ATTACHMENT 2 – REQUESTED CONSENT CONDITIONS

SSD-90134958 – 100 Edinburgh Road, Castlecrag

Council's requested local contributions, engineering, waste management, and public art conditions

Drawing No. C204		Revision 00	
										Title STORMWATER MANAGEMENT PLAN - BASEMENT LEVEL 3		Issued By SA	
										Checked By HR</

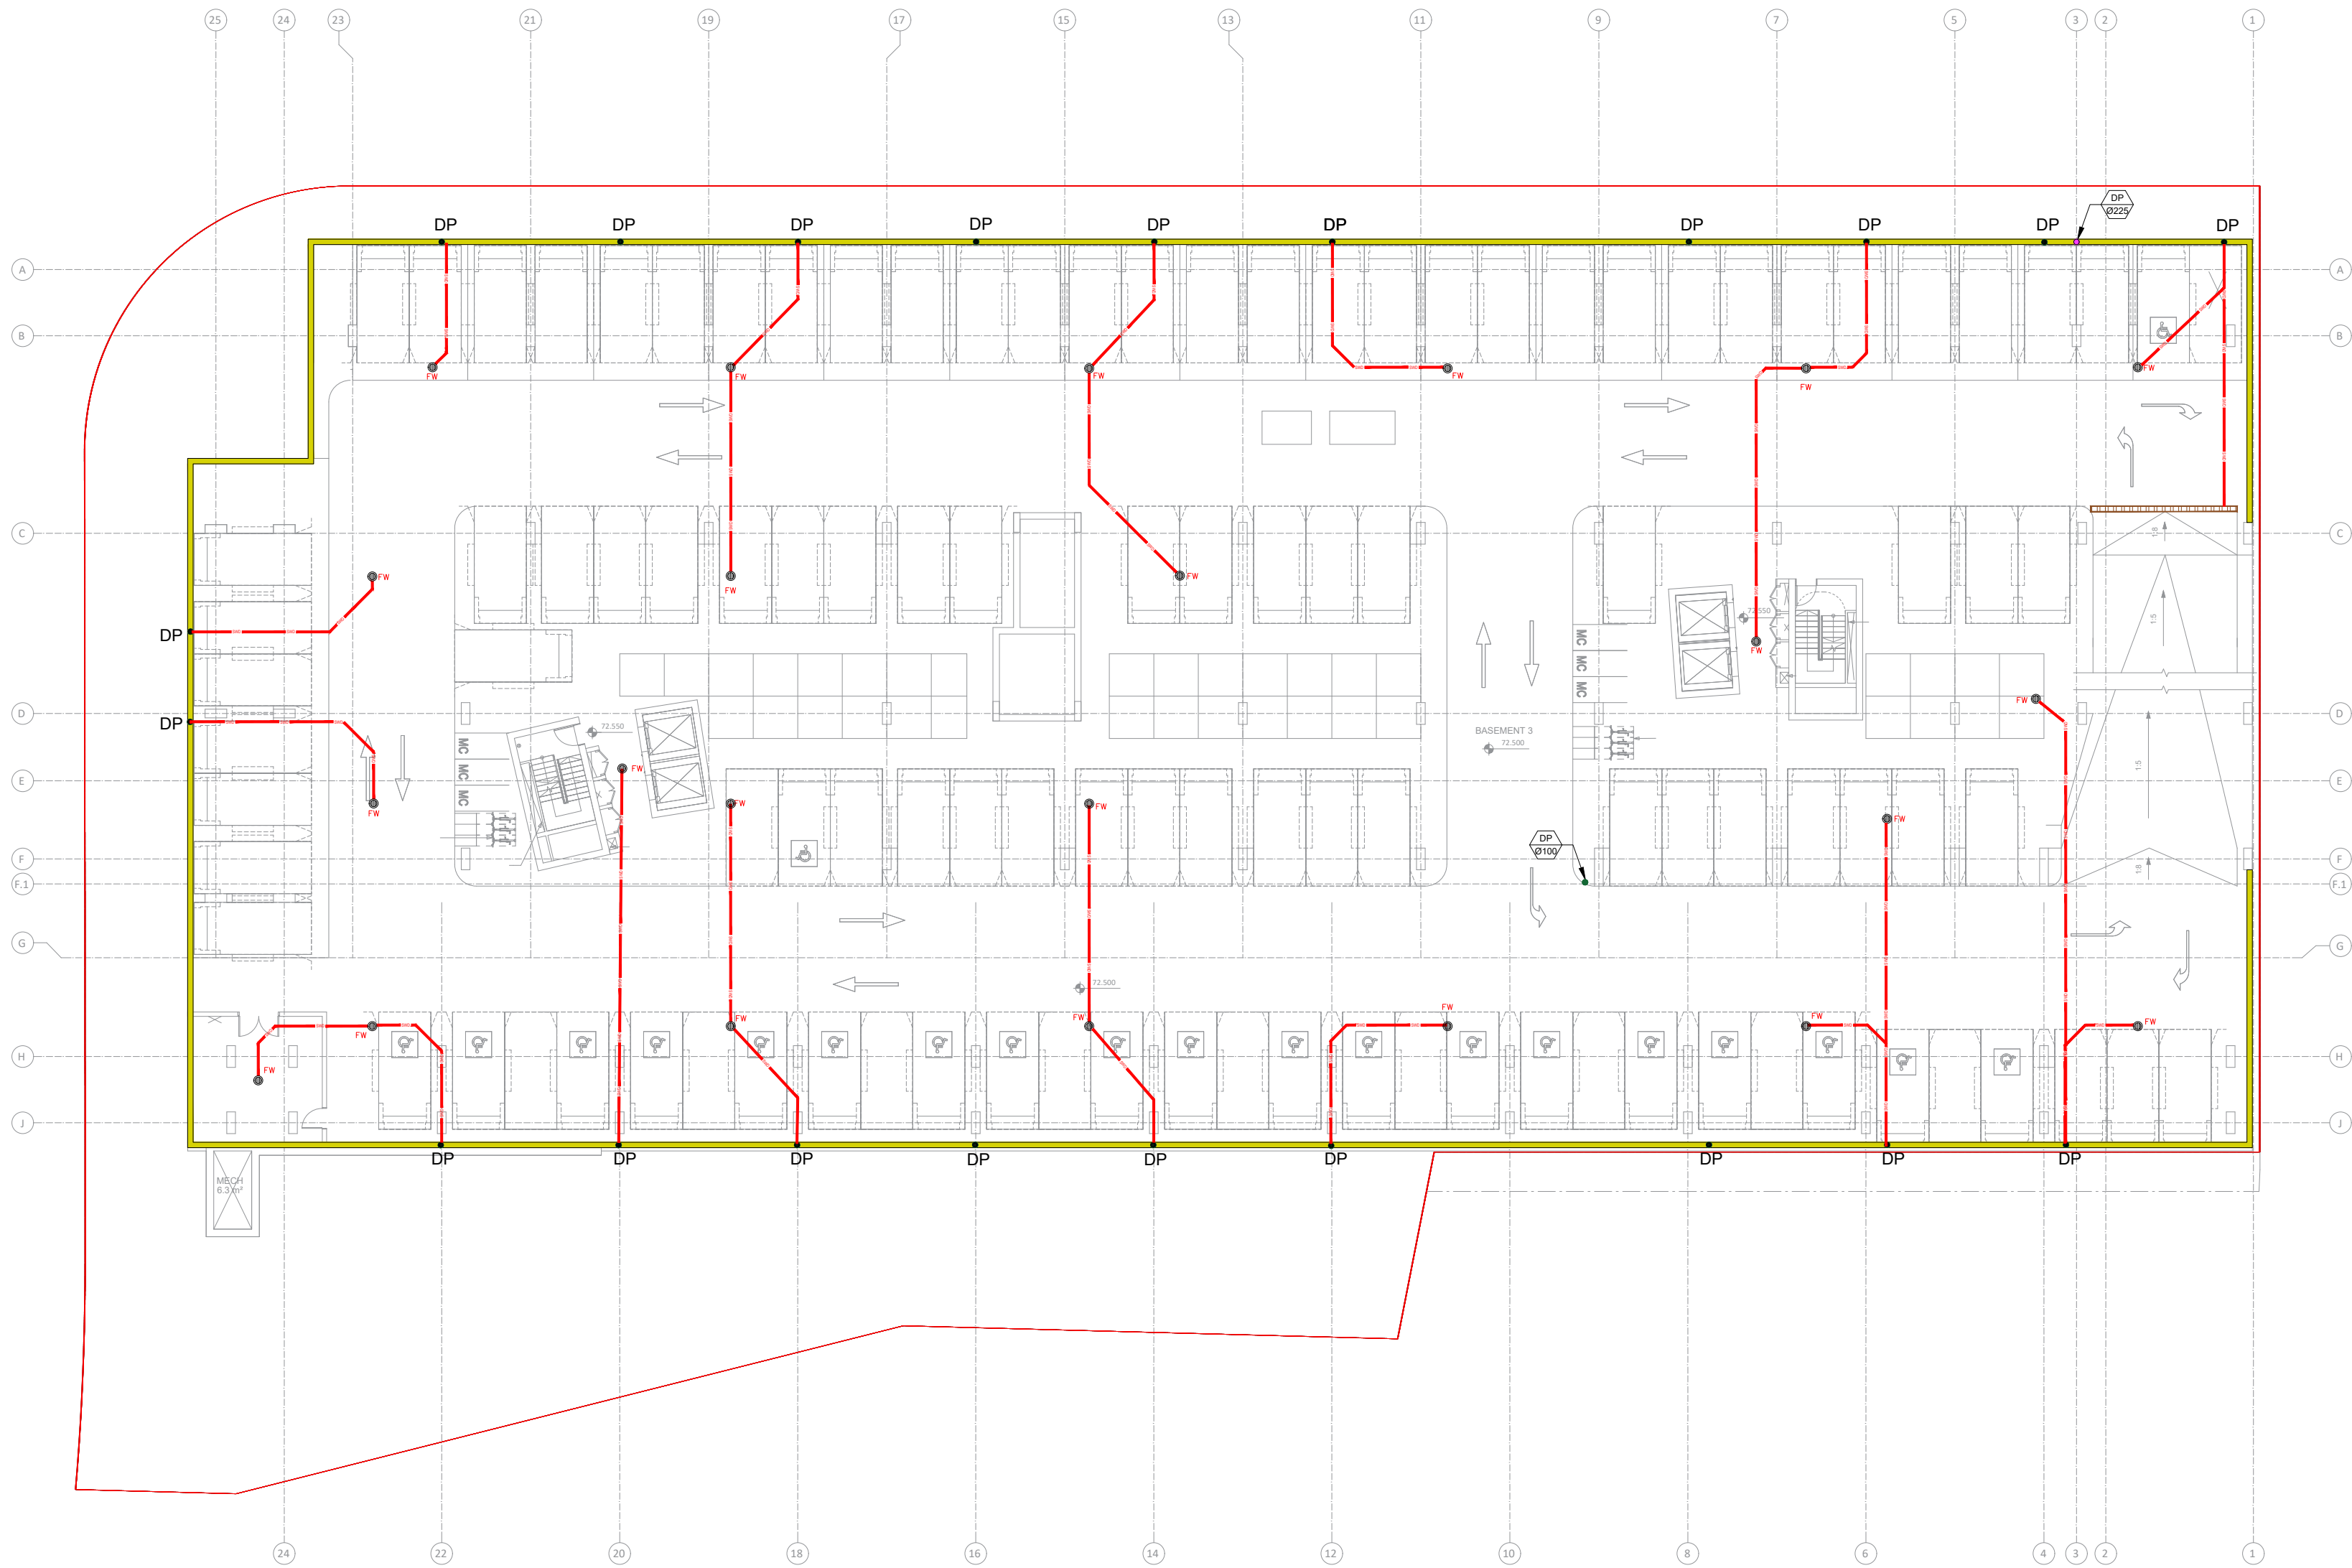
Prior to the issue of the Construction Certificate, the applicant shall submit, for approval by the Certifier, detailed stormwater management plans in relation to the pump-out drainage system. The construction drawings and specifications shall be generally in accordance with the approved stormwater management plans with the following requirements:

- (a) The pumpout drainage system shall comprise of two (2) submersible type pumps. The two pumps shall be designed to work on an alternative basis to ensure both pumps receive equal use and neither remains continuously idle.

- (b) Each pump shall have a minimum capacity of 10L/s or shall be based on the flow rate generated from the 1% Annual Exceedance Probability storm event 5-minutes duration of the area draining into the system, whichever is greater.

- (c) An alarm warning device (including signage and flashing strobe light) shall be provided for the pump-out system to advise the occupant of pump failure. The location of the signage and flashing strobe light shall be shown on the stormwater management plans.

- (d) The volume of the pump-out tank shall be designed with a minimum storage capacity equivalent to the runoff volume generated from the area draining into the tank for the 1% Annual Exceedance Probability storm event for 2-hours duration.

OSD TANK A
LAYOUT PLAN
SCALE = 1:50

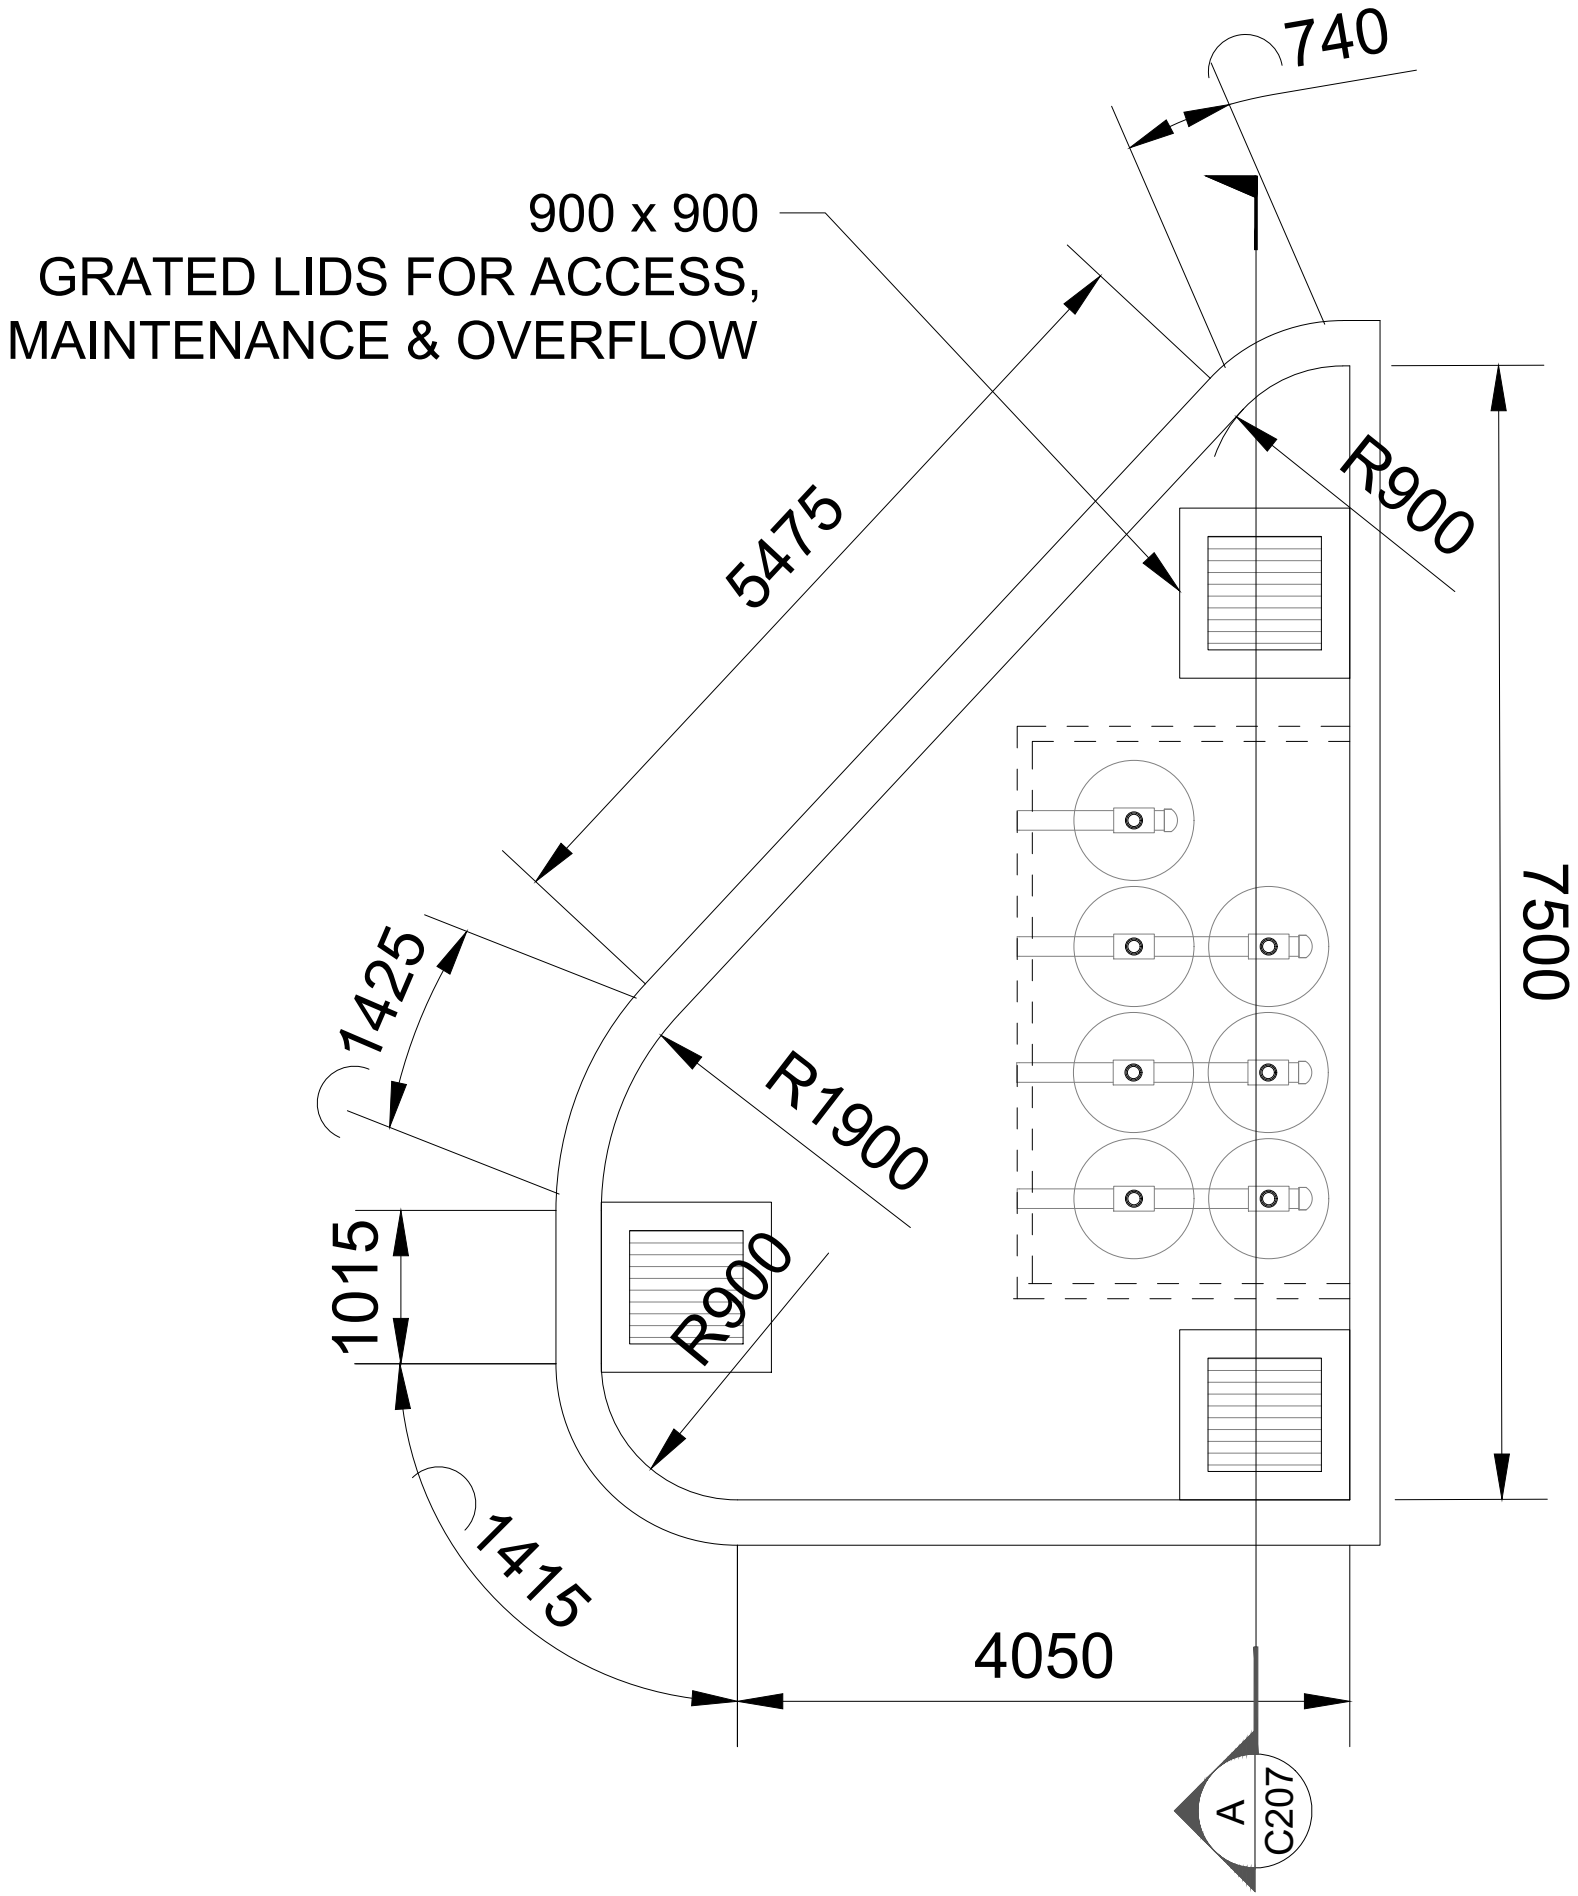
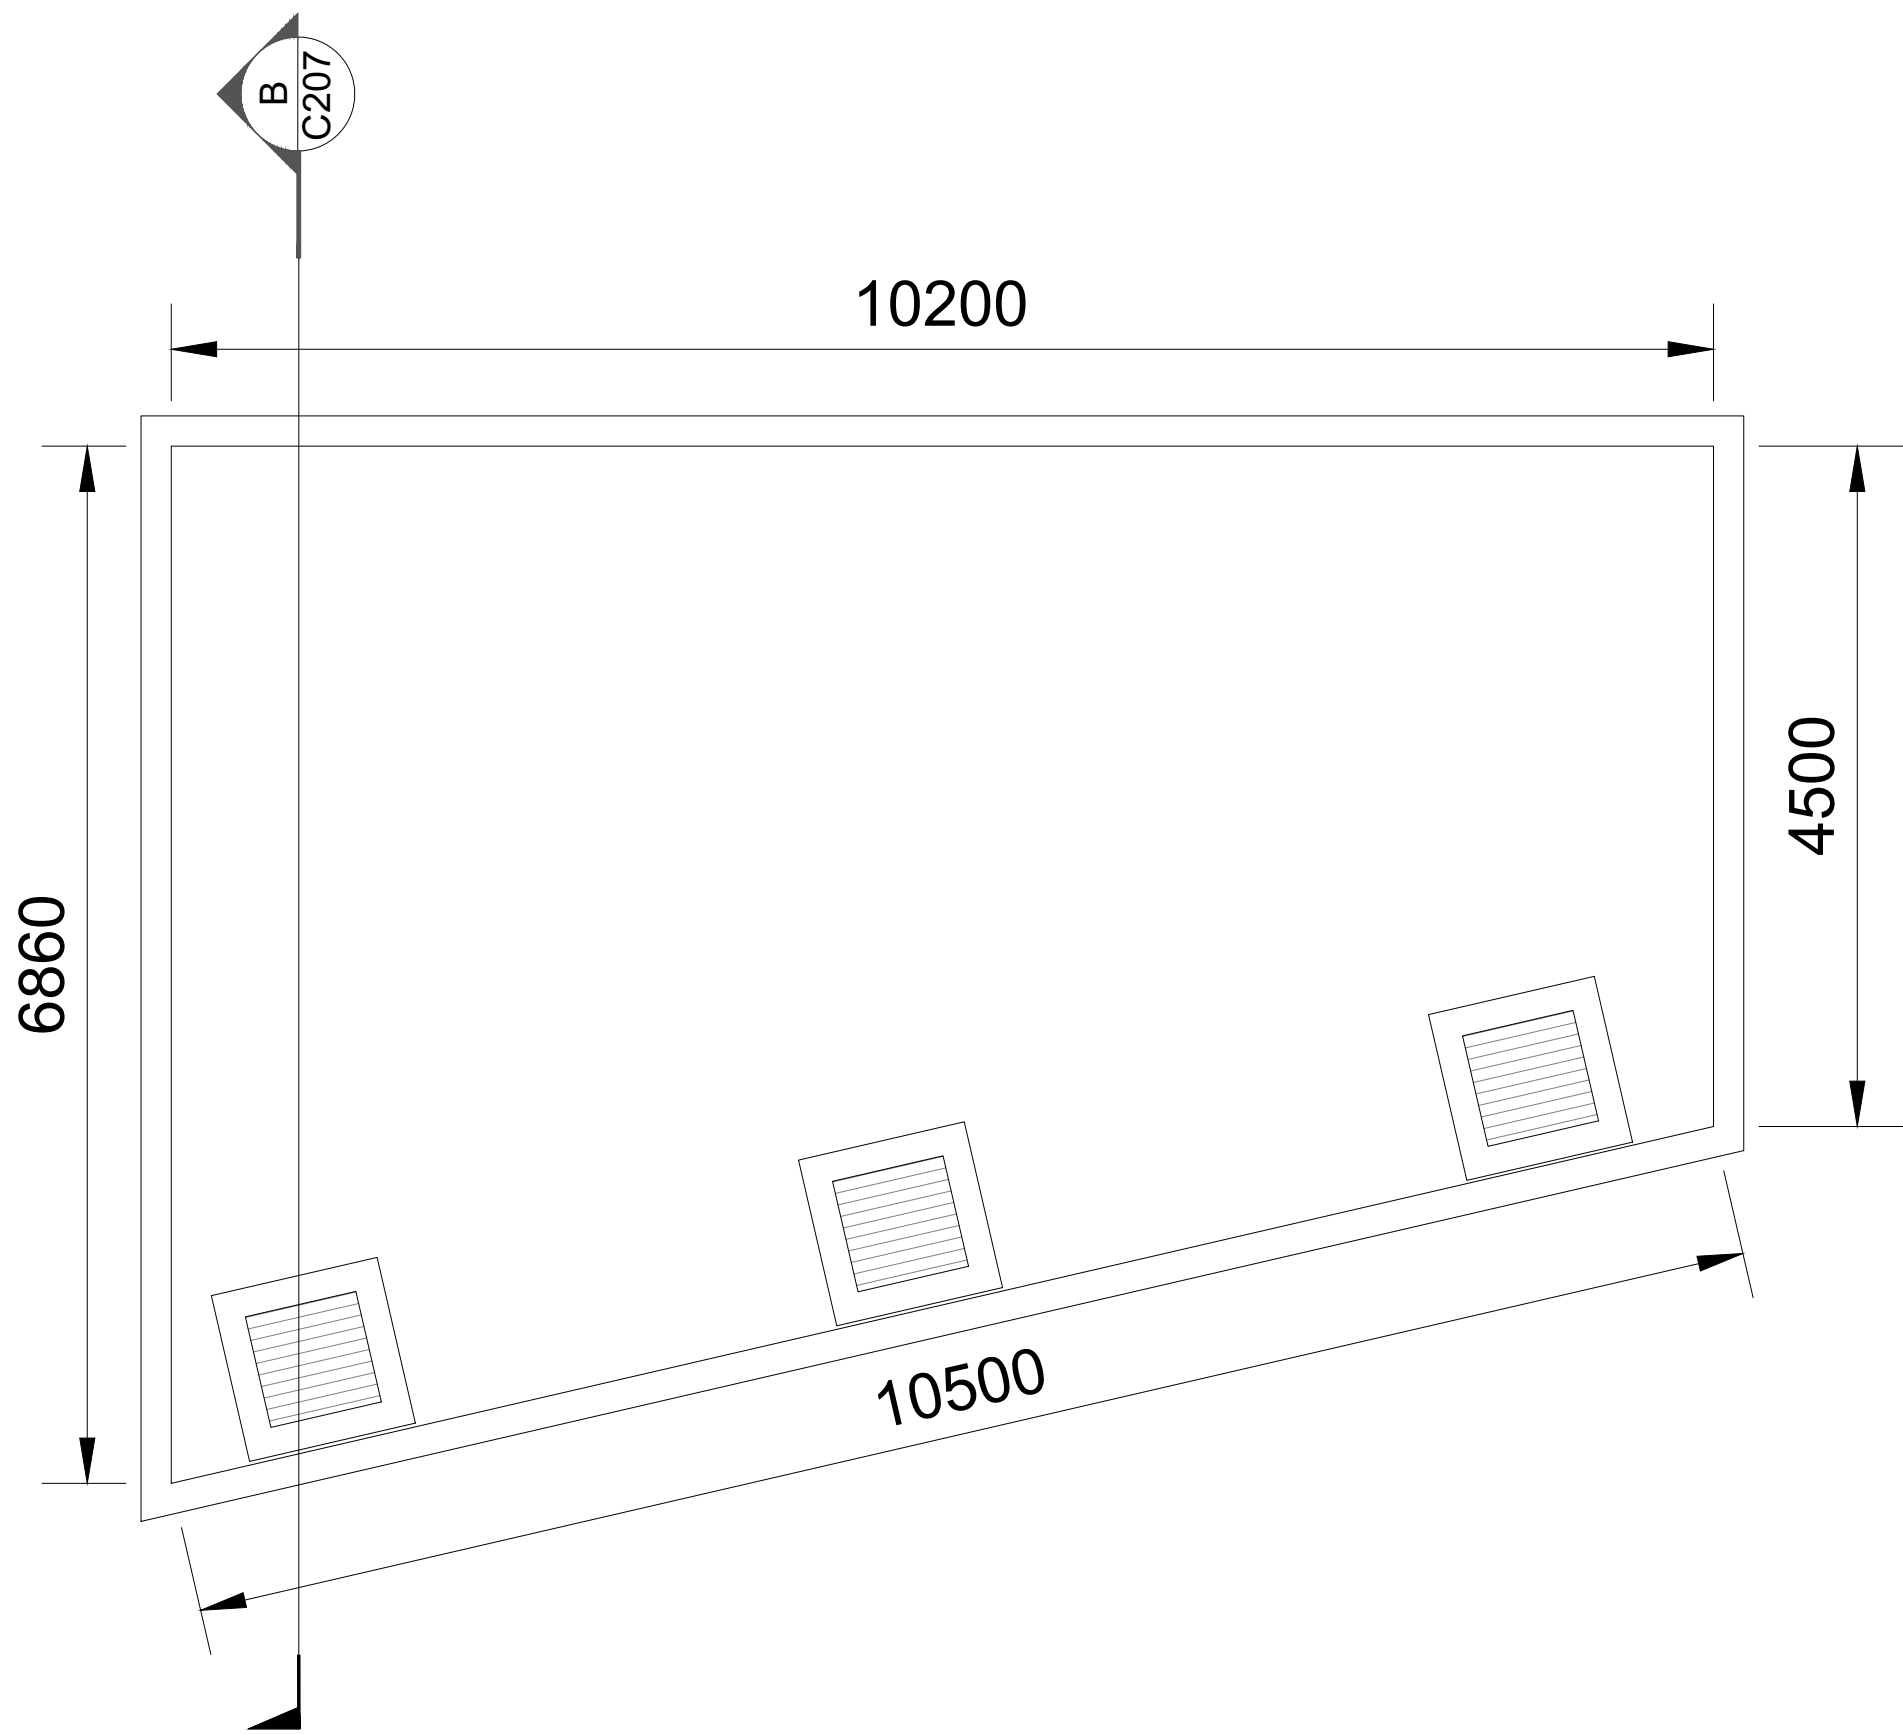
Prior to the issue of the Construction Certificate, submit to the Certifier for approval, detailed stormwater management plans in relation to the on-site stormwater management and disposal system for the development, which shall include an on-site stormwater detention system with a minimum volume of 293.4m³ that limits the peak flow from the site in the 1% AEP event to 107L/s. The construction drawings and specifications shall be
